Our ref: EoE/Ports/Tilbury2
Your ref:

25th July 2018

**MARINE ARCHAEOLOGICAL WRITTEN SCHEME OF INVESTIGATION V4 -
TRACKED CHANGES TILBURY2 DOCUMENT REF: PoTLL/T2/EX/150
REVISED VERSION OF DOCUMENT SUBMITTED AT DEADLINE 4 TO
EXAMINING AUTHORITY
Ref: TR030003**

Figure 2

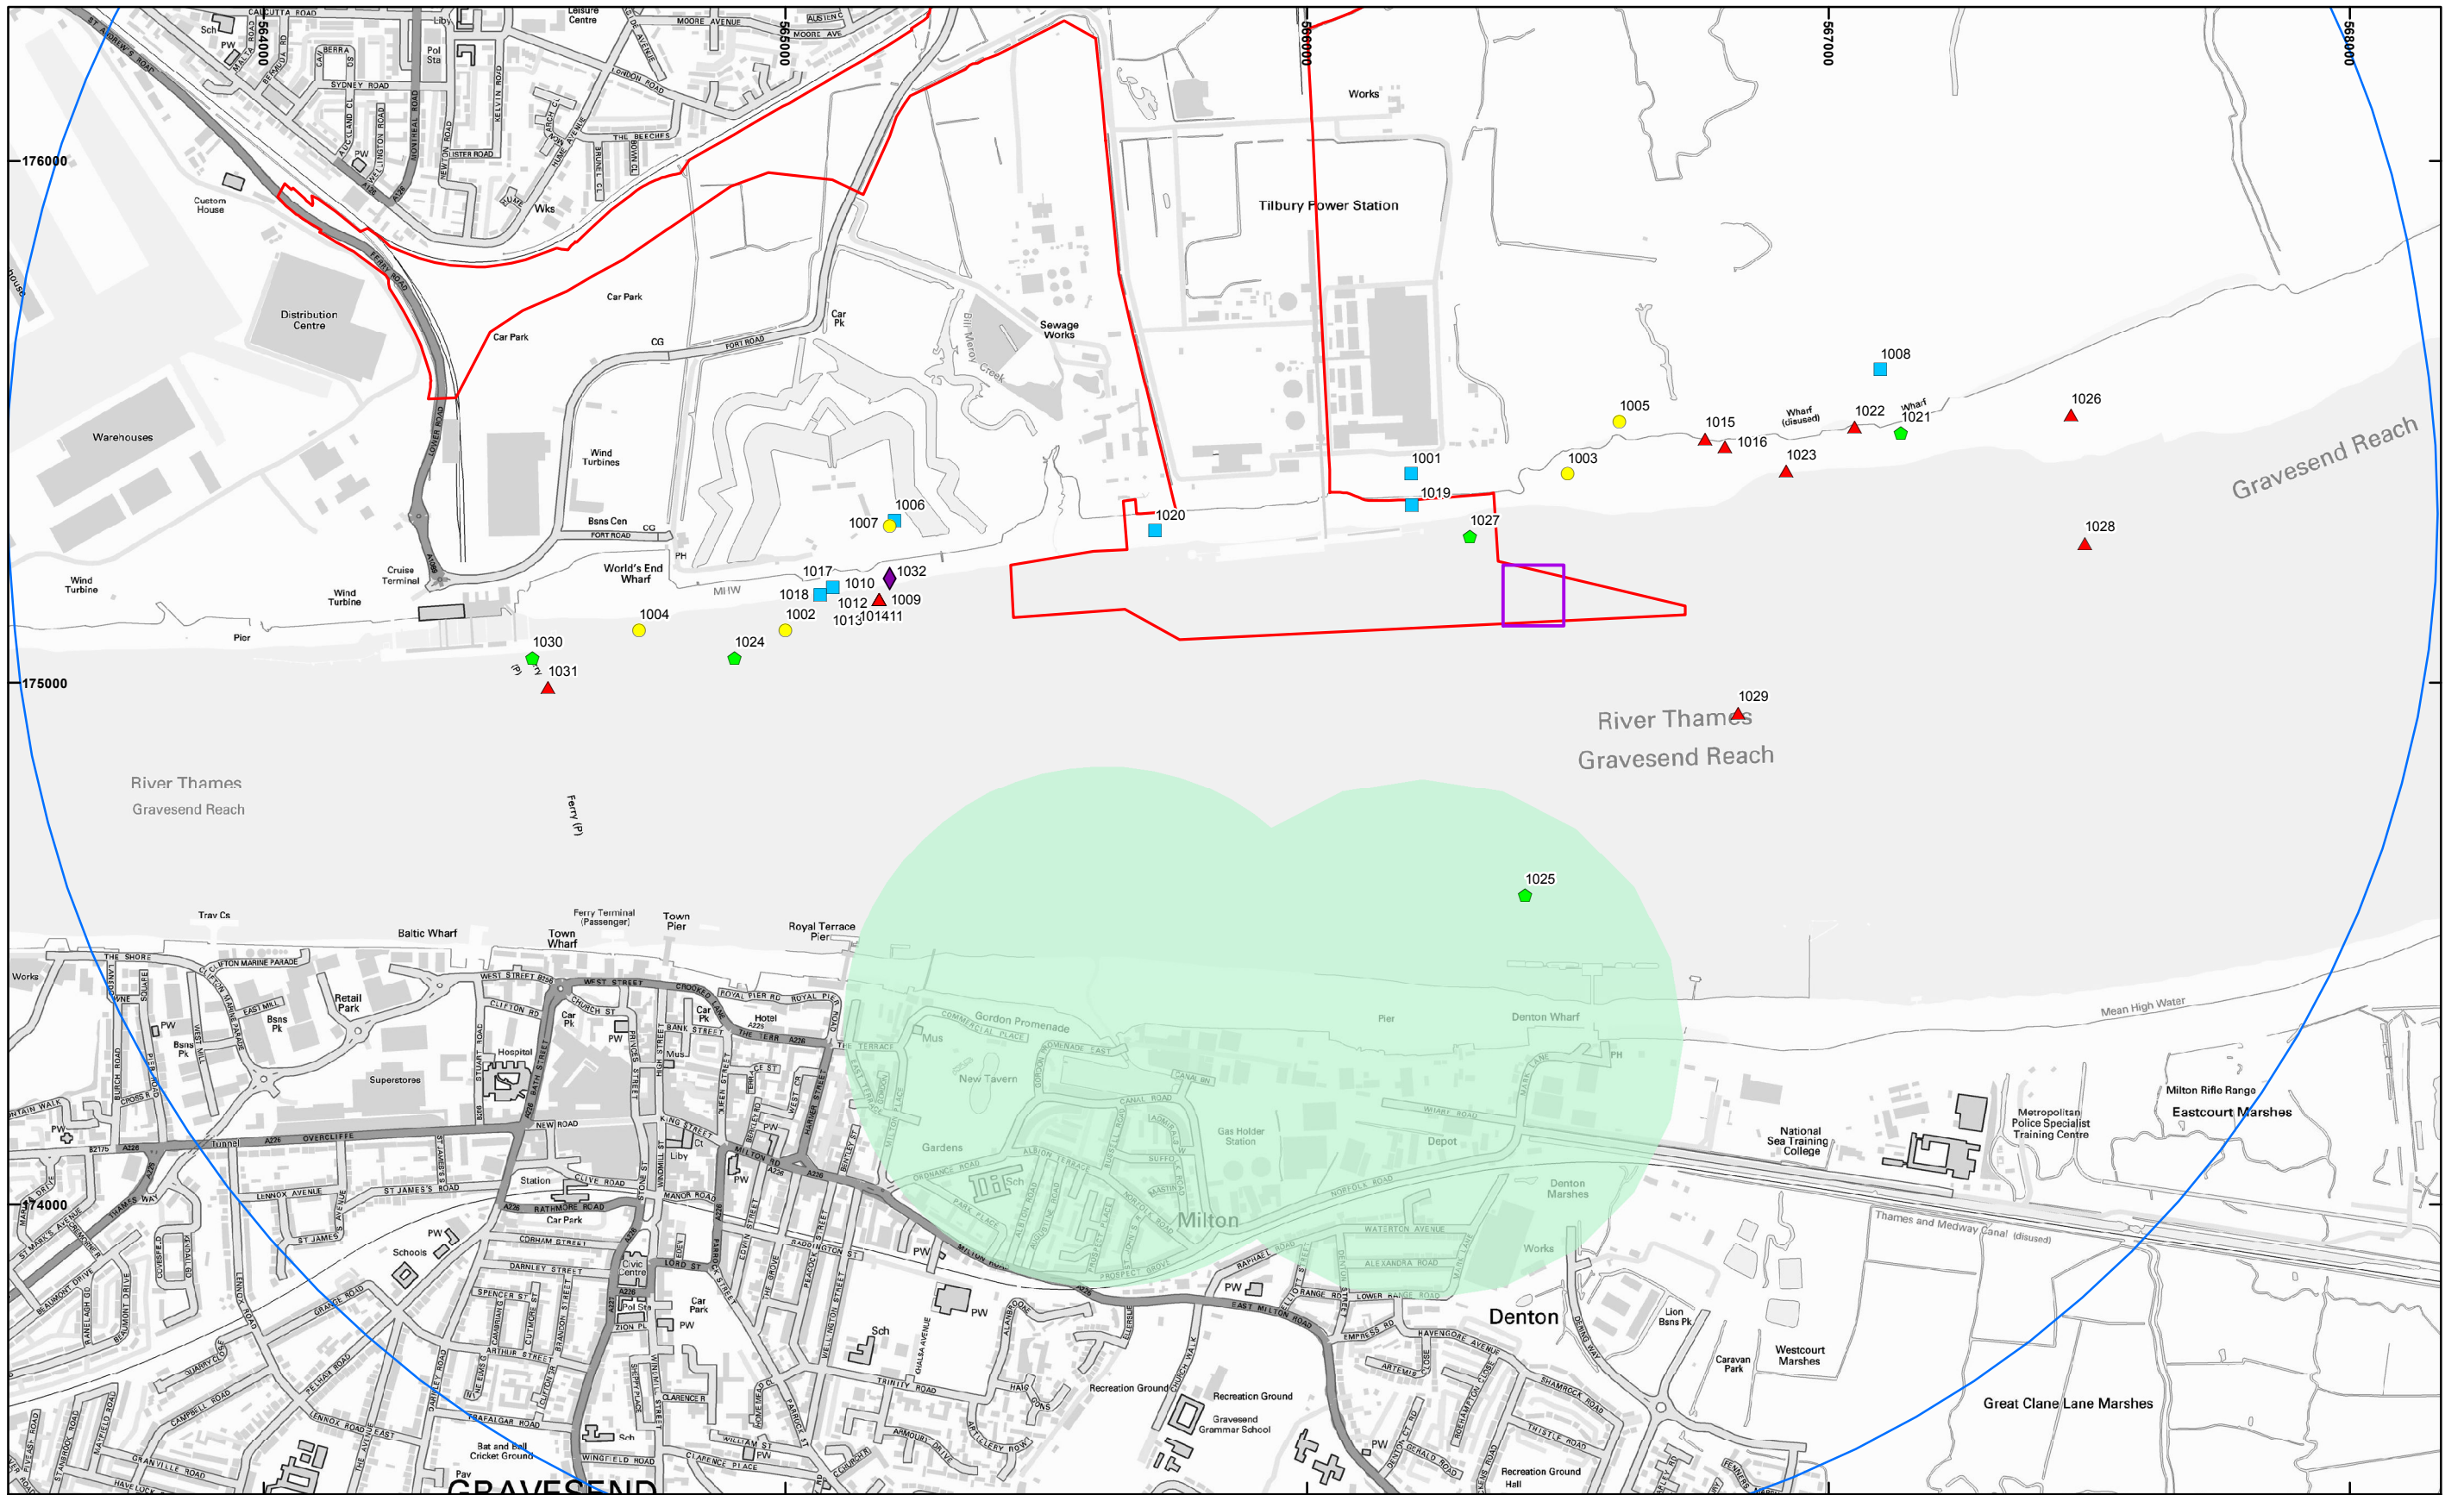
Figure 2 (CAD drawing of Proposed Development, we acknowledge the explanation provided to us regarding proposed dredge areas, berthing dolphins and upgrades to jetty, as set out in your email of 5th July 2018.

Figure 4

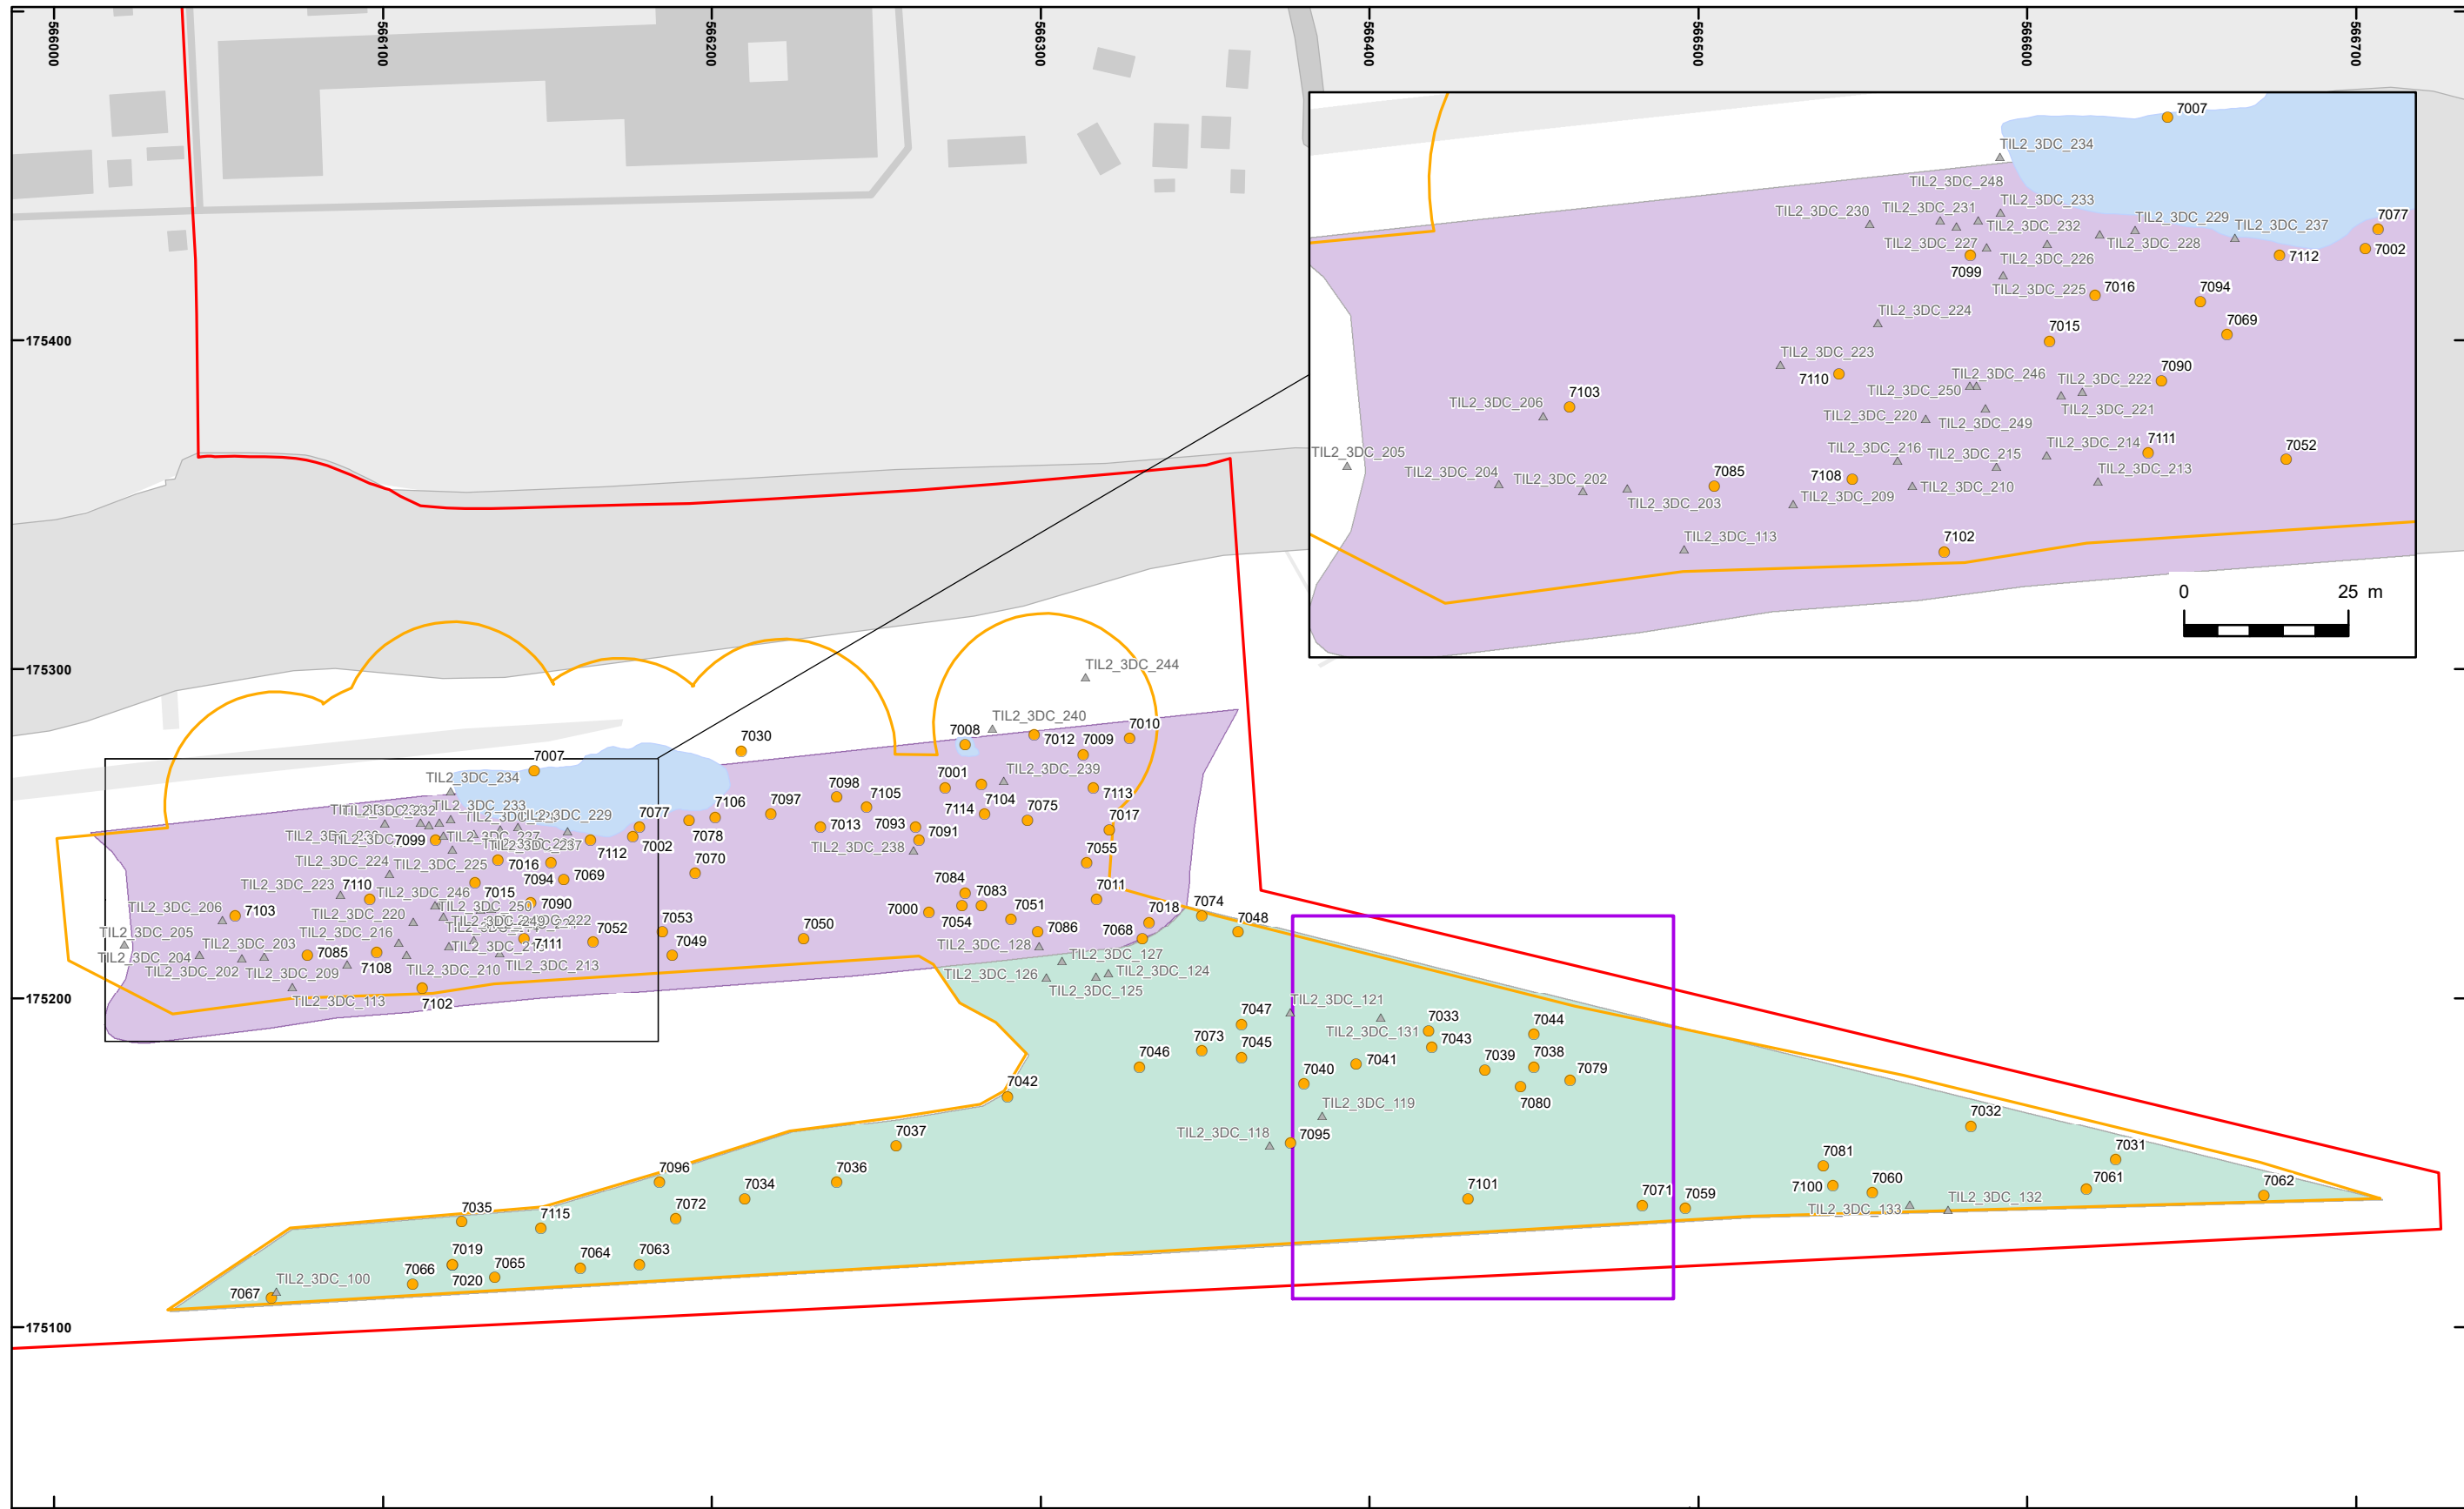
5.4.22 – We note that the revised text mentions Figures 4 and 5 to show locations of anomalies in relation to dredge pockets and we have no further comment to offer.
